Engineers Comments Regarding Surface Water Drainage

Application No: BN/35/22/DOC
Registered: 15th March 2022
Site Address: Shelley House Church Lane Eastergate PO20 3UR
Description of Works: Single storey rear extension and associated alterations. This application may affect the character and appearance of the Eastergate Square Conservation Area. BN/110/21/HH Conditions(s) 3 & 6

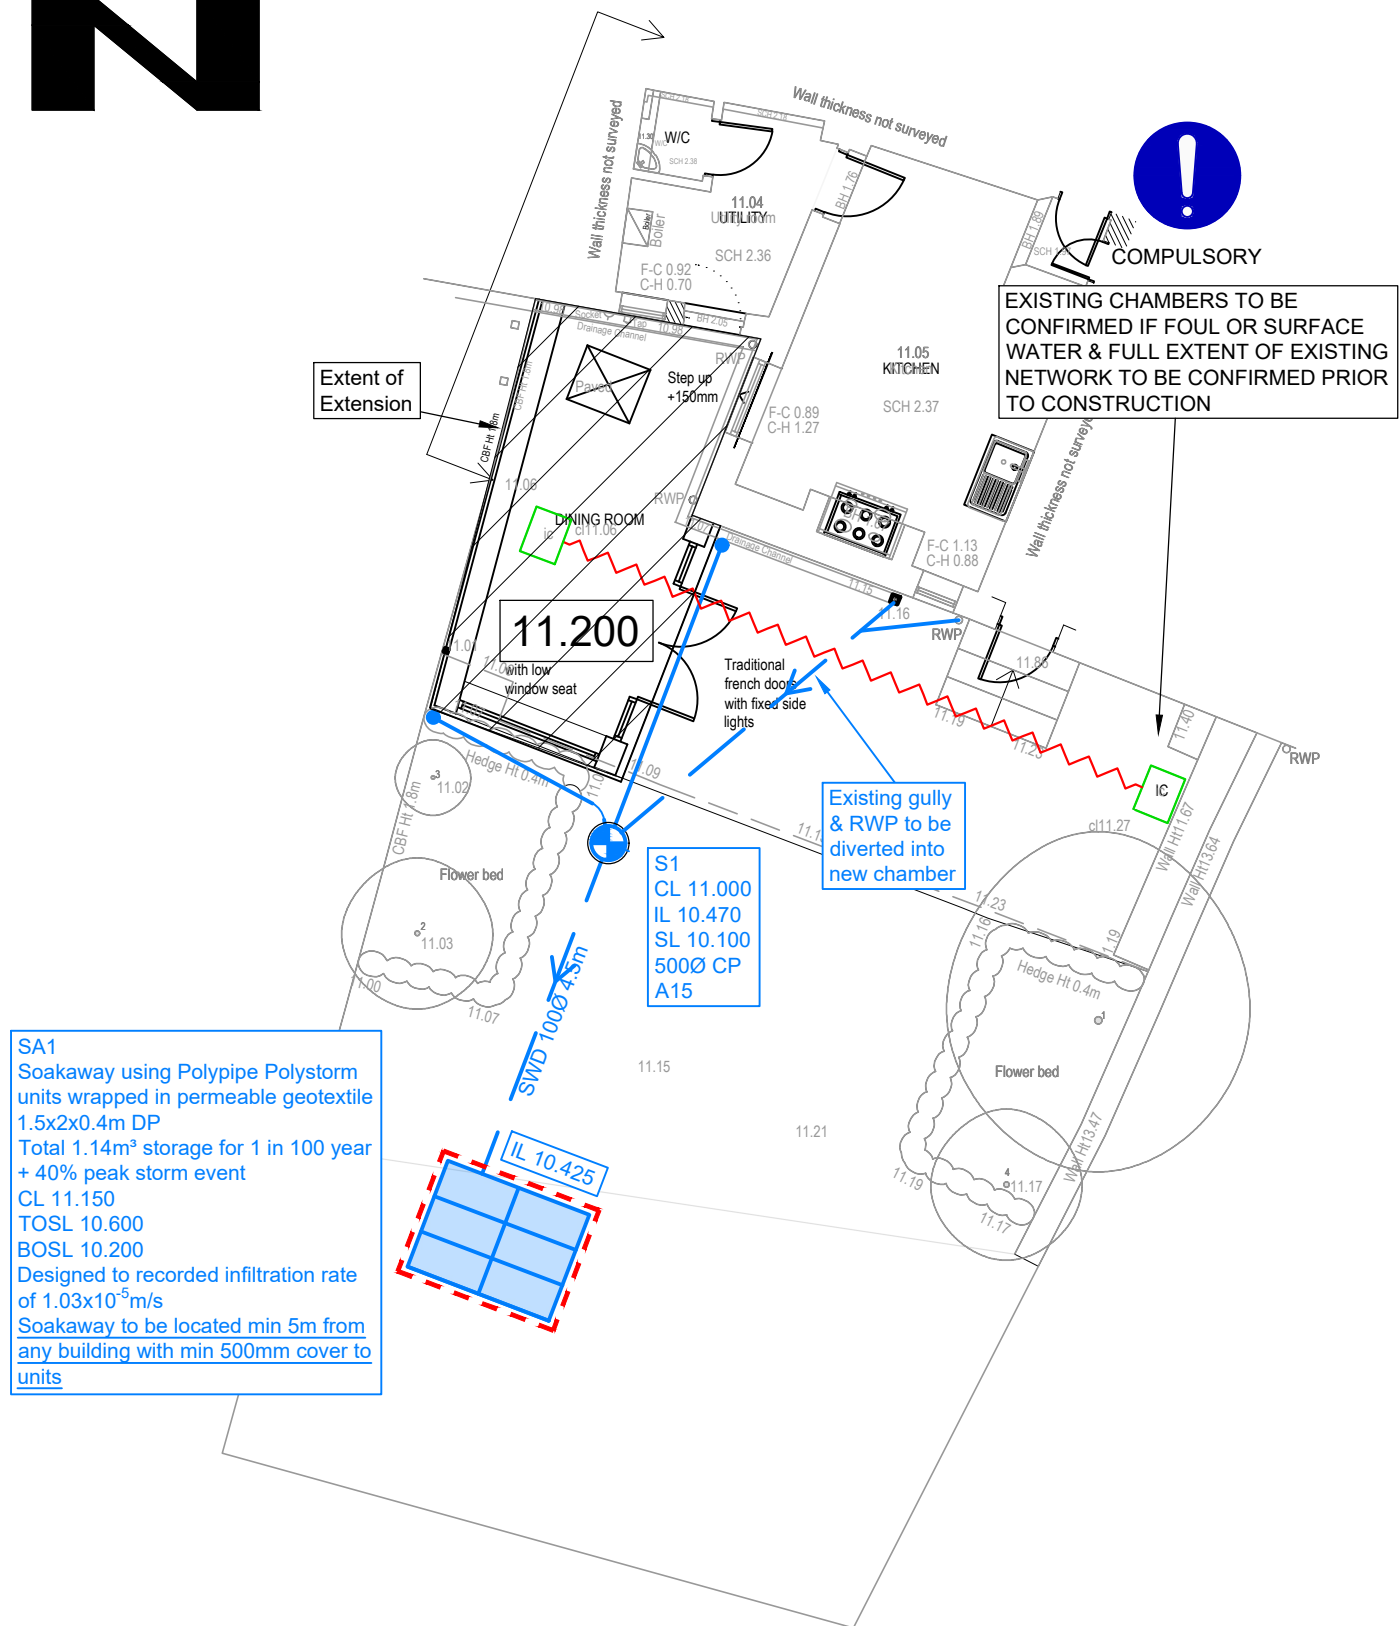
1. An impermeable area plan showing what areas from the existing roof and from the proposed extension will be drained to the new soakaway.
2. Please can the invert level of the incoming pipe to the soakaway be shown on the drainage layout. At present it could easily be misunderstood to be laid at the base of the soakaway.
